DRAINAGE AND TRANSPORTATION INFORMATION SHEET (REV 1/2016)

Project Title: Valle de Atrisco **Building Permit #:** BP-2017-30394 **Hydrology File #:** PO9 1002D
DRB#: _____ **EPC#:** 10044281/16-EPC-40037 **Work Order#:** _____
Legal Description: Lots RR-3 & RR-3A & RR-3B, located on Dennis Chavez Blvd. SW Albuquerque, New Mexico
City Address: 10001 Ceja Vista Road Albuquerque, New Mexico

Re: Valle de Atrisco
10001 Ceja Vista Rd.
Traffic Circulation Layout
Architect's Stamp 10-02-17 (P09-D002D)

## A1 TRAFFIC CIRCULATION LAYOUT

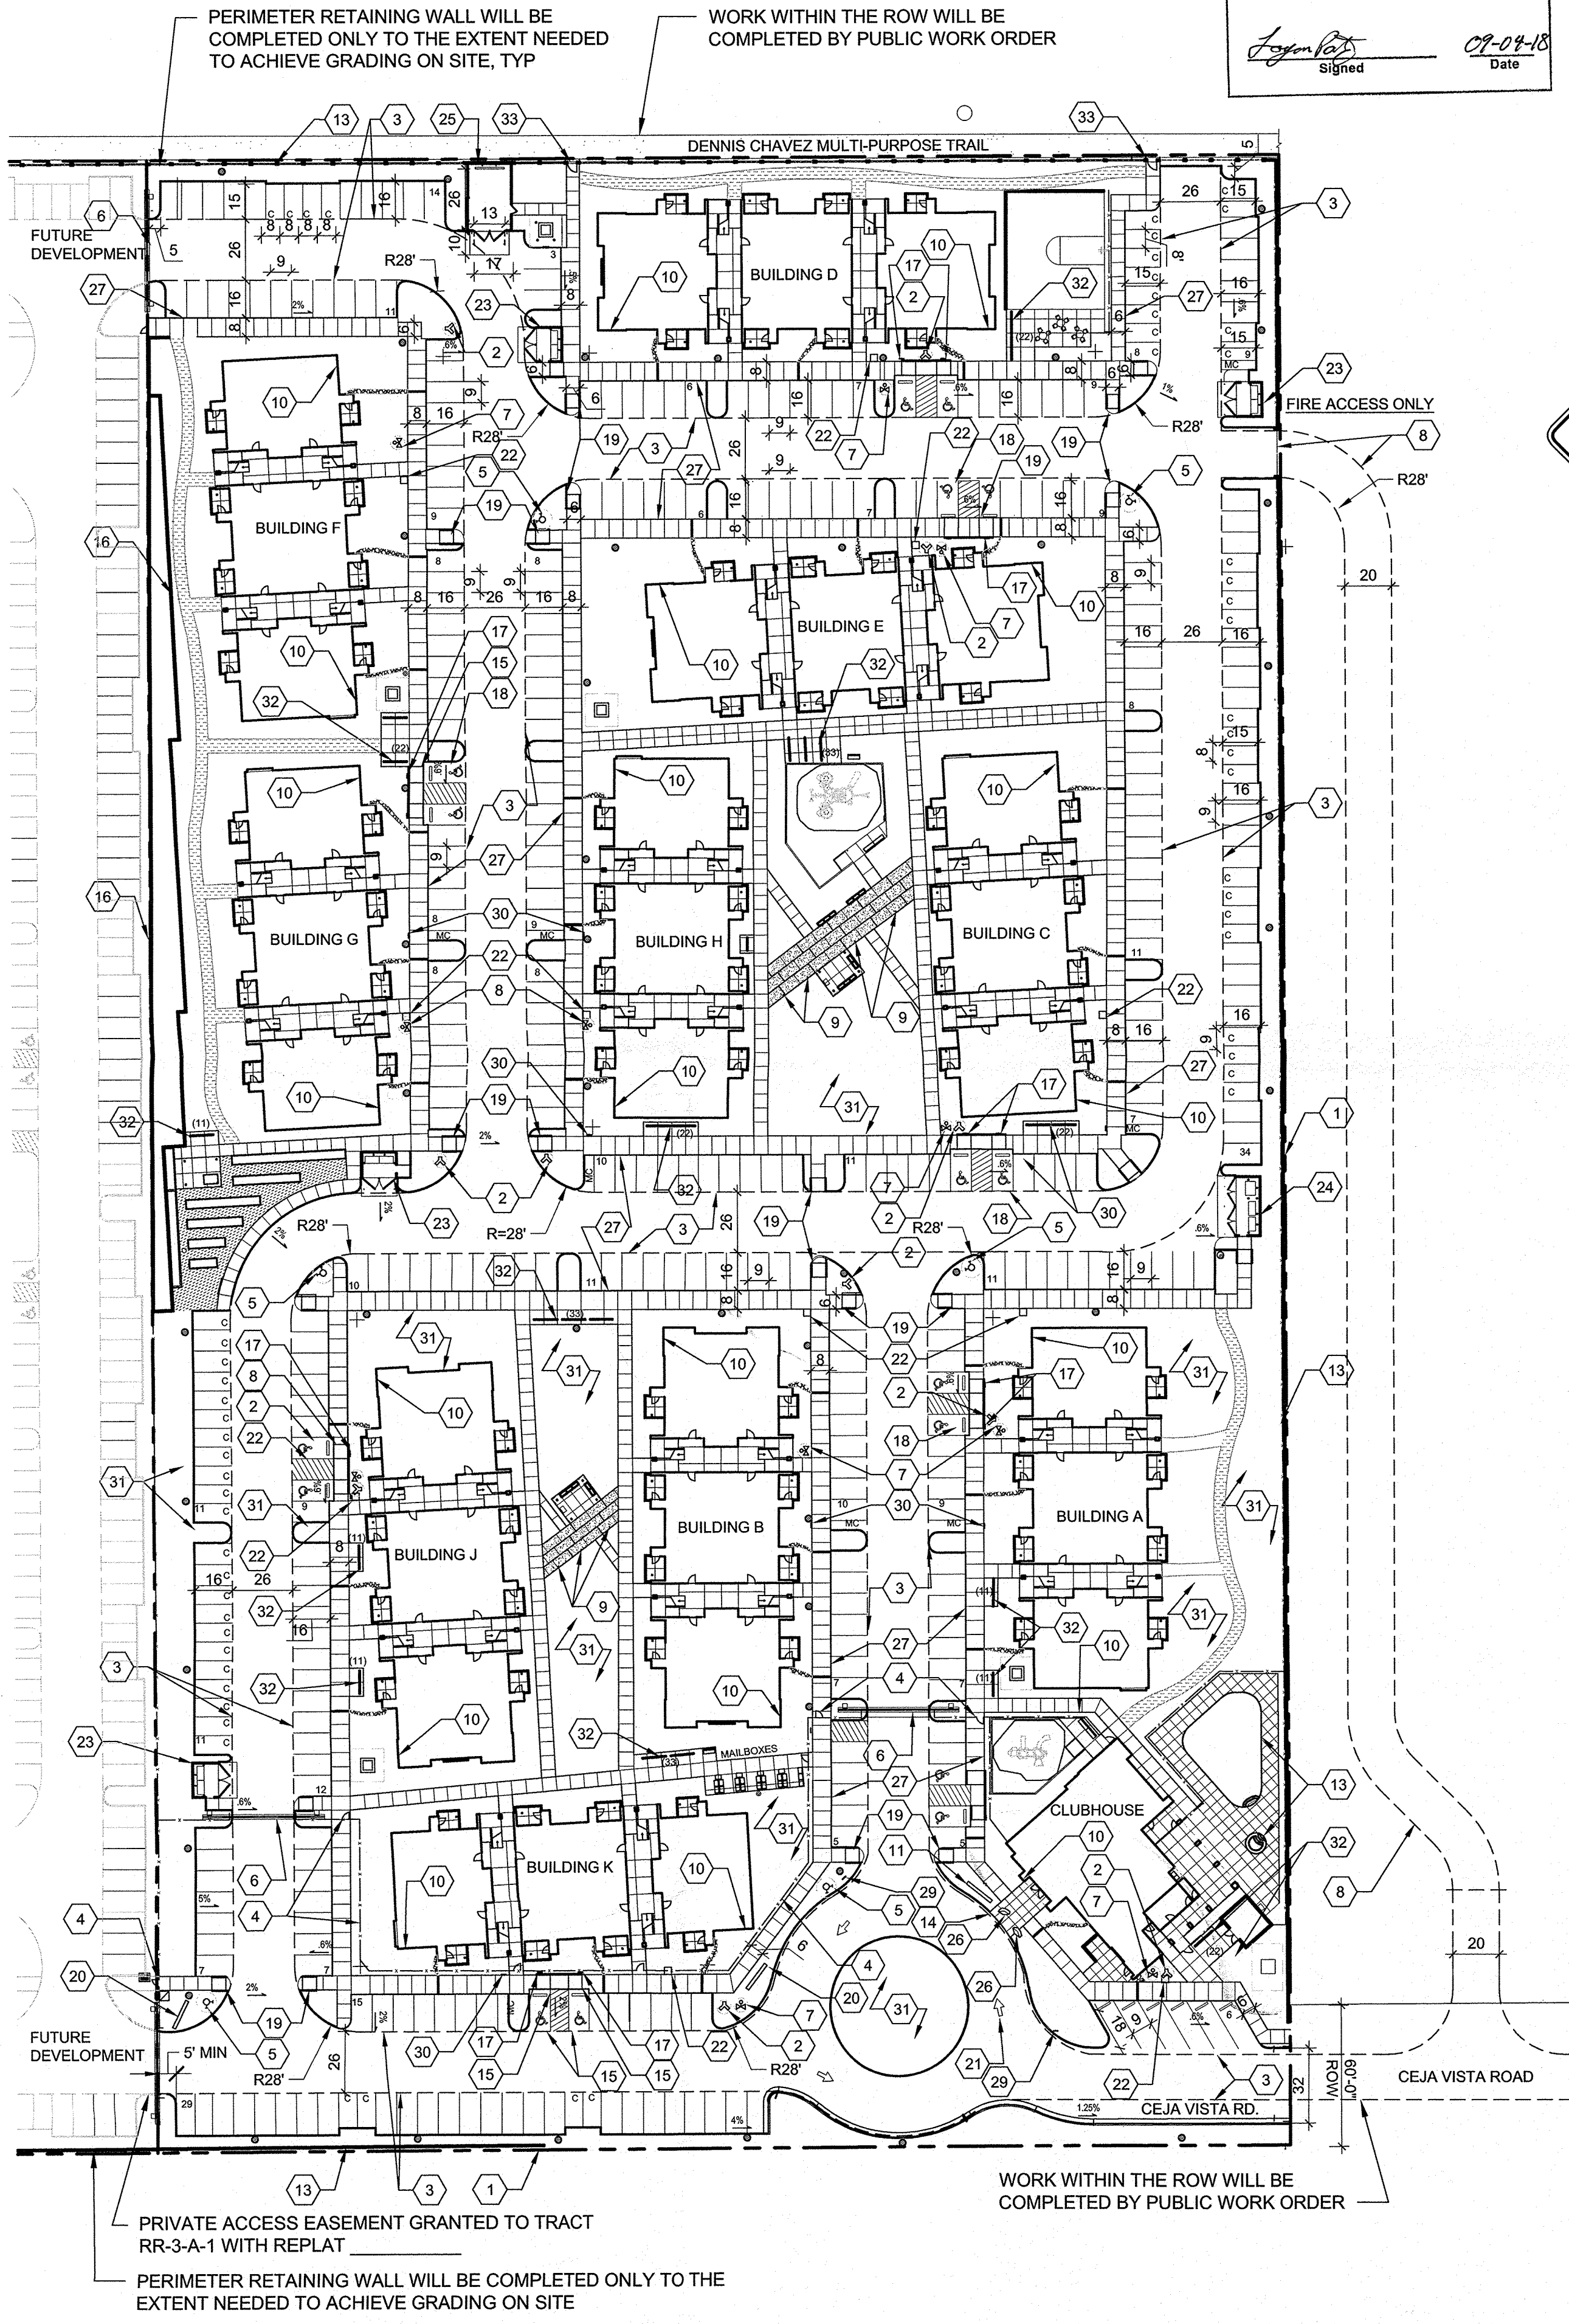
1. Dennis Chavez is a limited access road way. The emergency access must be approved off NM 500. Contact MRCOG to get approval from the Roadway Access Committee (RAC) and the Metropolitan Transportation Board (MTB).

2. Please coordinate with NMDOT District 3 Traffic for driveway permit on Dennis Chavez NM 500. Please include us in all correspondences. Contact Nancy Perea @ Nancy.Perea@state.nm.us and Margaret Haynes @ Margaret.Haynes@state.nm.us.

3. Identify all existing access easements and right of way width, and street widths on Ceja Vista Rd and Dennis Chavez Blvd. Roadway shall be built with DRC approved City Work Order.

4. A 5 ft. keyway is required for dead-end parking aisles. The parking space next to the southwest gate should be removed. The spot is too close to the gate for vehicles to maneuver.

5. All sidewalks and trails along streets should be placed at the property line.
6. Please include a copy of your shared/cross access agreement with the adjacent property owner.

7. Please add a note on the plan stating "All improvements located in the Right of Way must be included on the work order."
8. Work within the public right of way requires a work order with DRC approved plans.
